Subject: RE: BE/176/21/PL - The Cottage, Shripney Road, Bognor Regis - WSCC Highway Query Northern Footway from site to Robin Hood Public House/ Bus Stop

Subject: BE/176/21/PL - The Cottage, Shripney Road, Bognor Regis - WSCC Highway Comments/Query relating to the submitted planning documents

I've just been reviewing the above application and would raise the following points/query's.

Drawing:
2109058-02A

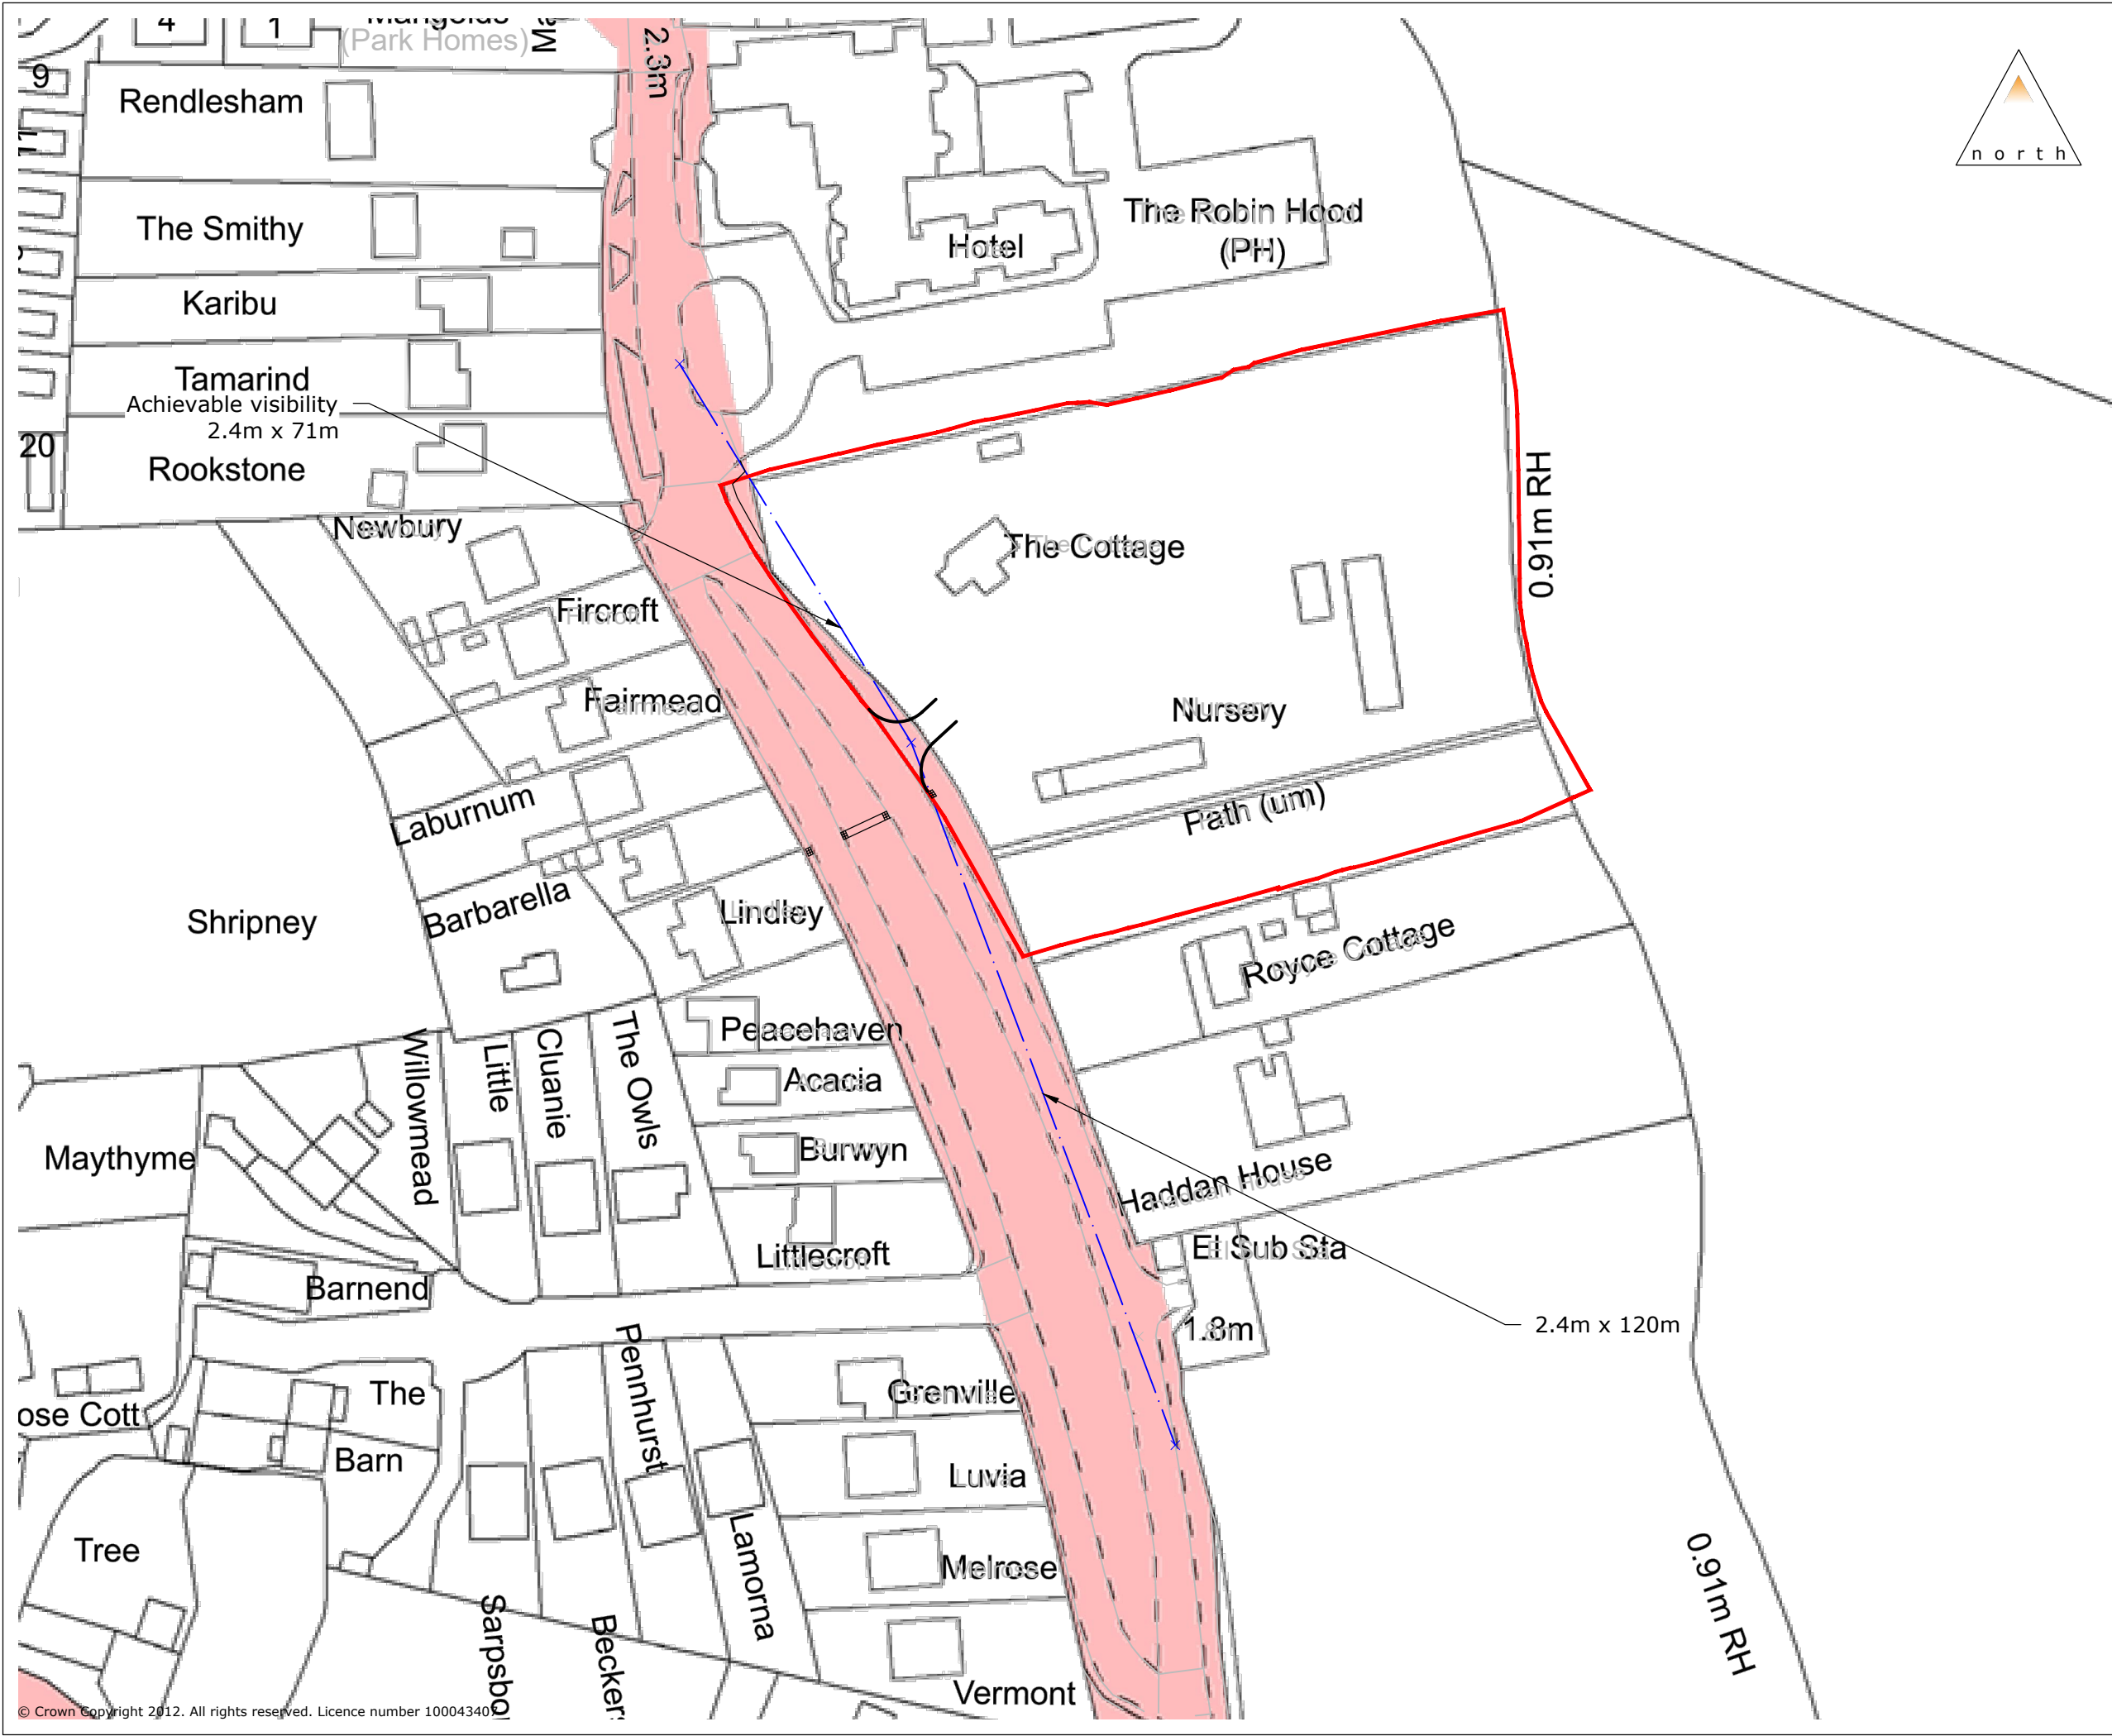
We do have concerns in relation to the northern footway at the site frontage shown on the approved 'Proposed Footway Arrangement' Drawing no: 160818-06 Rev A and the attached Proposed Site Plan (drawing no: PO22-9PA-03A). As far as I am aware this arrangement was not safety audited, or submitted to the LHA for review at the time of the BE/63/17 application. We have concerns that this footway will dump pedestrians (some elderly) out onto the A259/ the exit of the Robin Hood Pub car park. There is no indication of how this will tie in with this exit point. There is also then the issue of it being disconnected from the bus stop outside the pub, pedestrians would have to either walk through the pub car park, on the grass verge or the A259 to reach the bus stop that provides a direct sustainable transport link into Bognor Regis. Drawing PO22-9PA-03A with the new application is even more of a concern as the footway provision just stops before even reaching the pub car park exit point. Clarification on the sites pedestrian access strategy is required.

We would wish to see a plan detailing tactile paving/dropped kerb crossing points located on both the pub entry/exit points to tie in with this provision of footway, also a section of footway between the two entry and exit points and on the northern side of the entry point leading directly to the bus stop hard standing waiting area, this would then provide safe and continuous footway provision for all. We do not agree it would be acceptable to just terminate the footway at the end of the northern site boundary next to the pub vehicle exit point.

Drawing 2109058/06 attached details the visibility splays from the access as those previously agreed on the previous applications, while Drawing 2109058/07 details the pedestrian forward visibility splays as previously agreed.
